DESIGN PROFESSIONAL INSPECTION FORM

Residential Single-Family Project: <input checked="" type="radio"/> Y <input type="radio"/> N	Commercial Project: <input type="radio"/> Y <input type="radio"/> N
Code Enforcement Project No:	Permit No: SFD2305-0093
Project Name: New Single Family Dwelling	Owner: All Home Renovations LLC
Project Address: 42 Club Rawls Ct. Fuquay-Varina, NC 27526	Suite No:
Date Inspected: 6-16-23	Contractor Name: All Home Renovations LLC
Component Inspected: Footings

FOUNDATION PLAN
SCALE: 1/4"=1'-0"

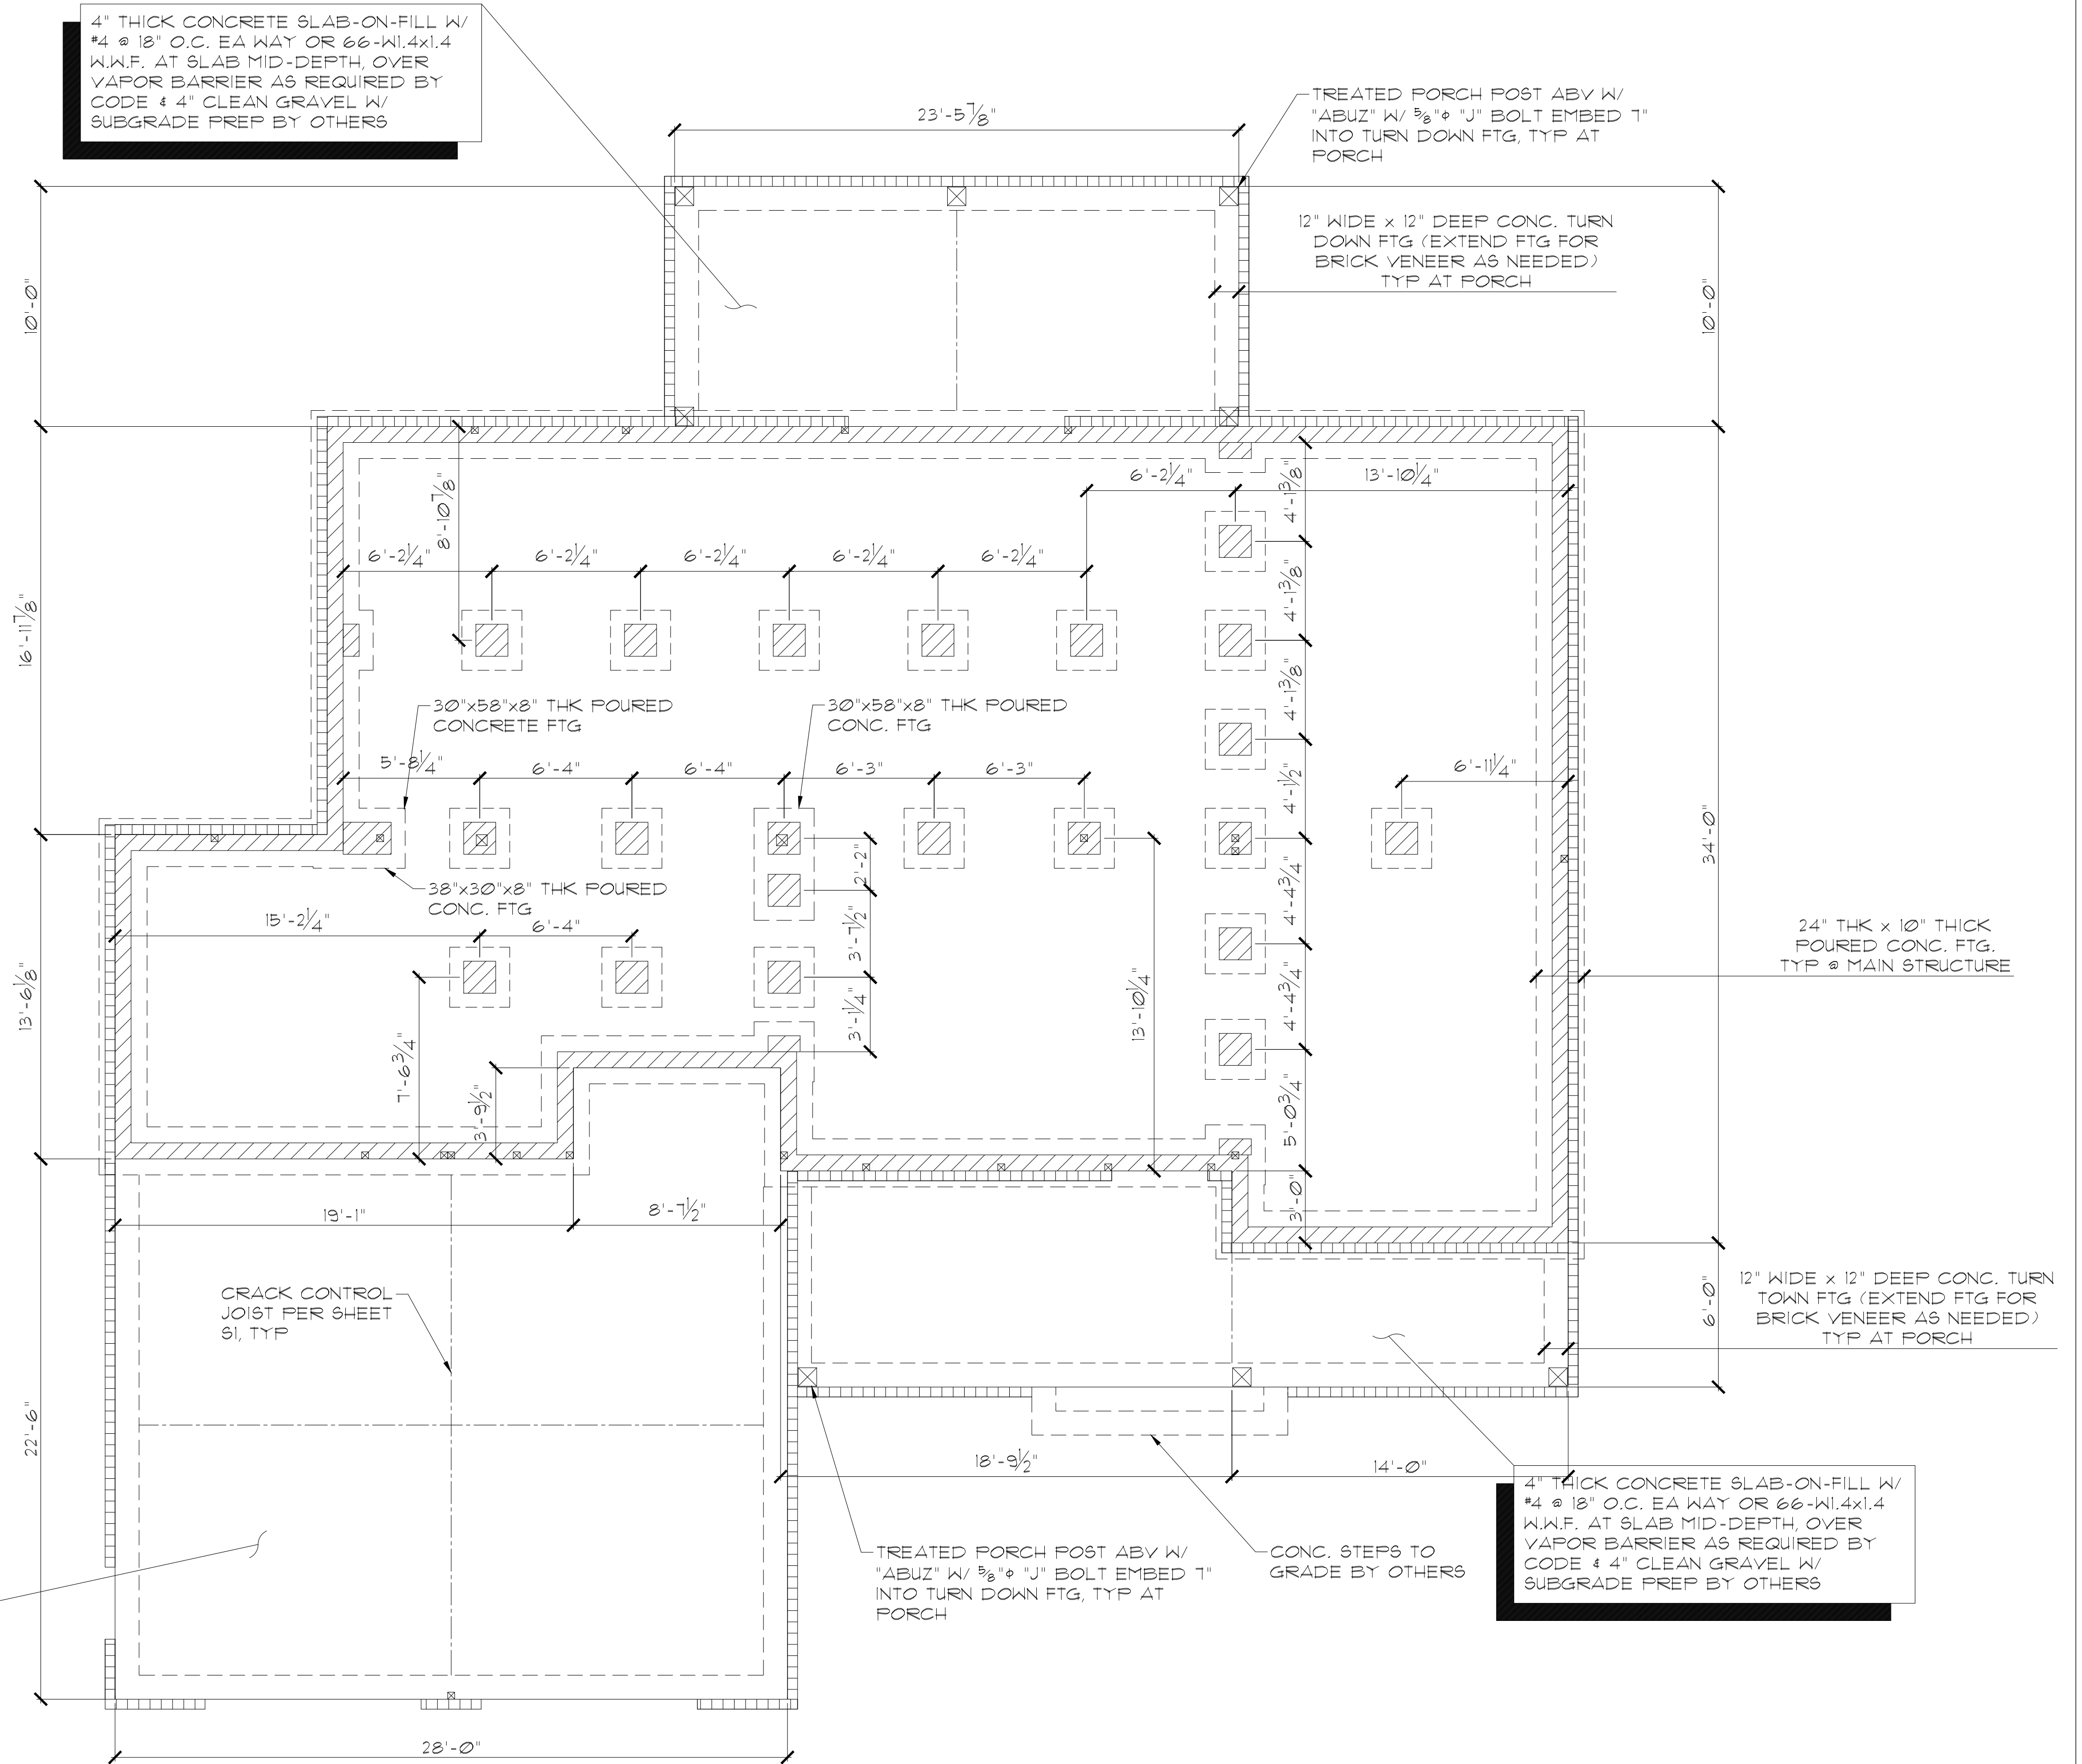
Notes: 1) Continuous footings were excavated 18" wide in lieu of plan specified 24" wide. There will be no brick veneer on the house and 18" wide footings are sufficient. 2) Porches will be of typical wood deck construction bearing on 6x6 posts on 16"x16"x8" footings. All footings met the requirements of the 2018 NCRC and were approved for concrete placement.
